**Peer Review Response to
Bylong Coal Project Heritage Review Report
prepared for Planning Assessment Commission
by GML Heritage May 2017**

A report prepared by
Chris Betteridge, Betteridge Consulting Pty Ltd
t / a MUSEcape

for
Hansen Bailey Pty Ltd
on behalf of
WorleyParsons and KEPCO Bylong Australia Pty Ltd

8 June 2017

Figure 2.20 Tarwyn Park with heritage and Natural Sequence Farming features marked. (Source: Six Maps with GML overlay)

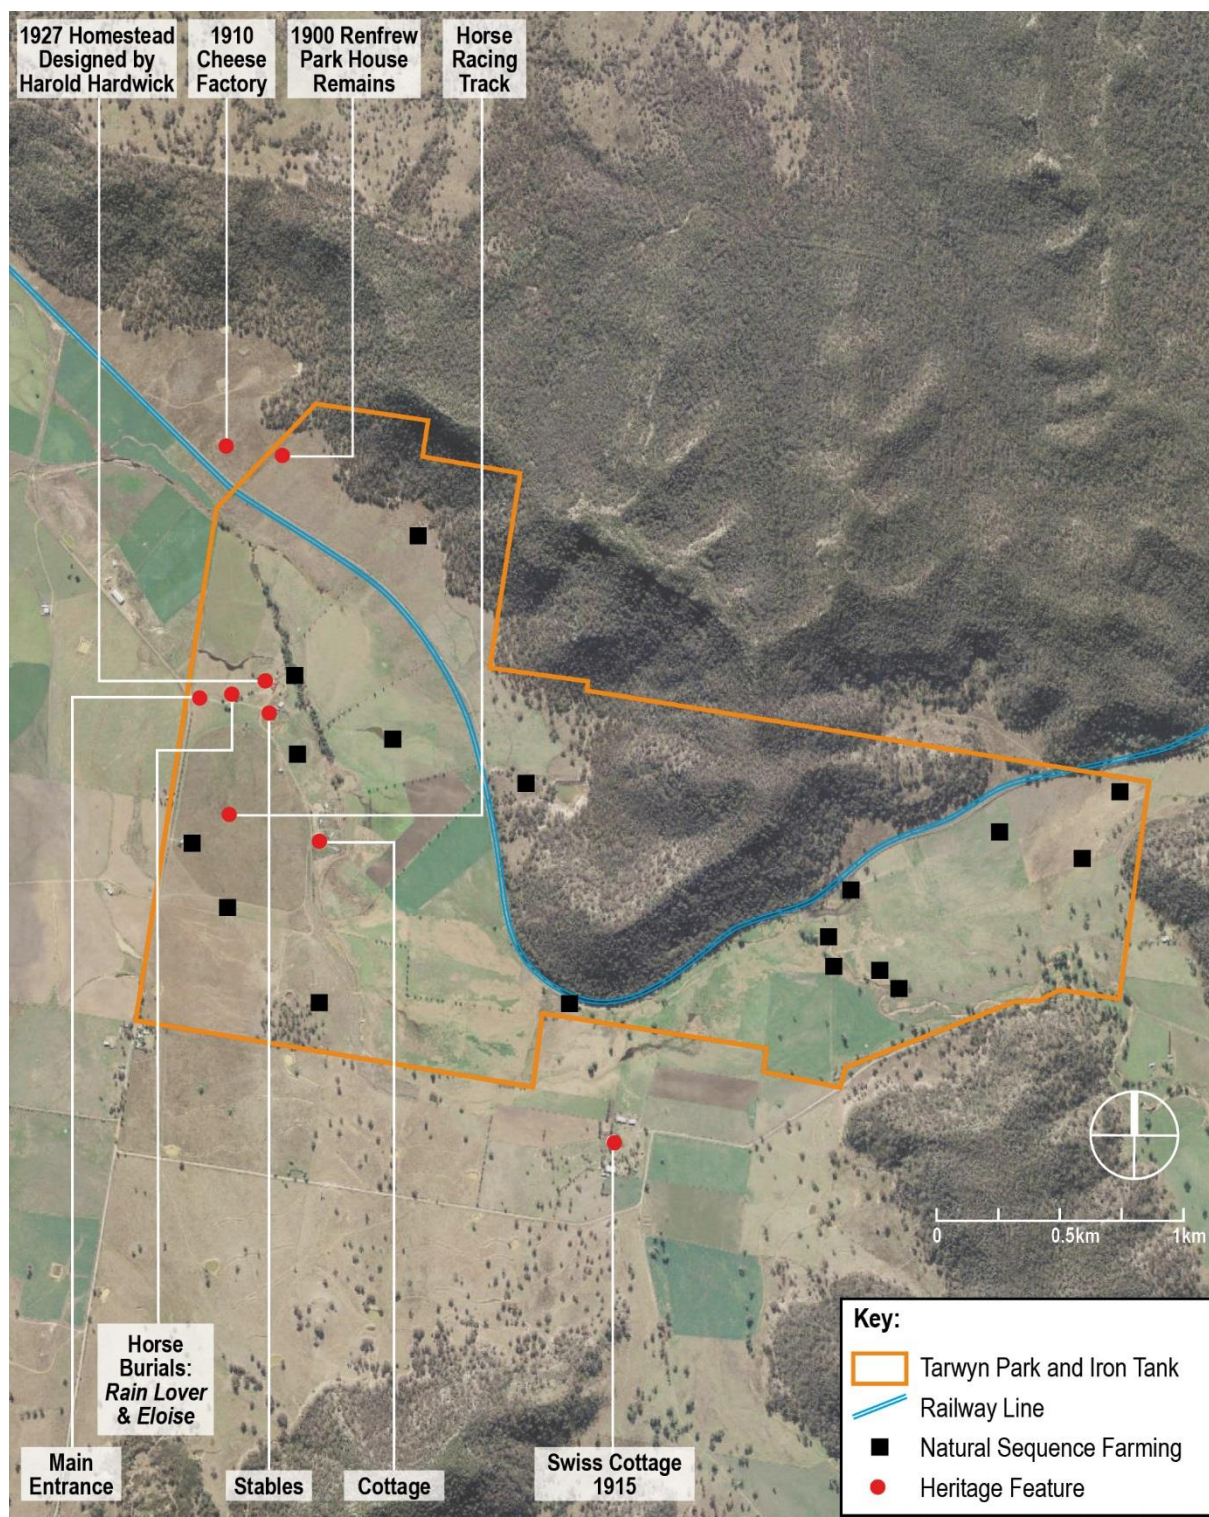
8	Figure 2.20	Horse Burials: Rain Lover and Eloisa (incorrect spelling on figure) are shown in the wrong location. They should be at the main entrance. The Swiss Cottage is also shown in an incorrect location on the figure. It is further to the north west of the location shown.
9	Figure 2.20	The structure shown as a "cottage" is in fact a hay shed. Additionally, it is unclear why this particular cottage is shown as a 'heritage feature' – there is no comment in the text regarding the heritage significance of this structure. Additionally, there is no text or commentary in the text related to the "Horse Racing Track", which is also identified as a 'heritage feature'.
10	Section 2.4.2	There are two typographical errors in the last paragraph on page 11.
11	Section 3.1, Table 3.1	In the table under the NSW Theme "Convict", William Lee is listed as a former convict servant but he was not a convict. He is discussed more accurately in Section 2.2 as the son of convict Sarah Smith and William Pantoney, alias Panton. The information under the NSW Theme "Exploration" is inaccurate: Tindale was a convict assigned to Cox. Lee was not a road maker with Cox but was recommended by Cox as a suitable settler to receive a grant, as described more correctly in Section 2.2. The relevant NSW historic themes cited by GML Heritage do not include the following:
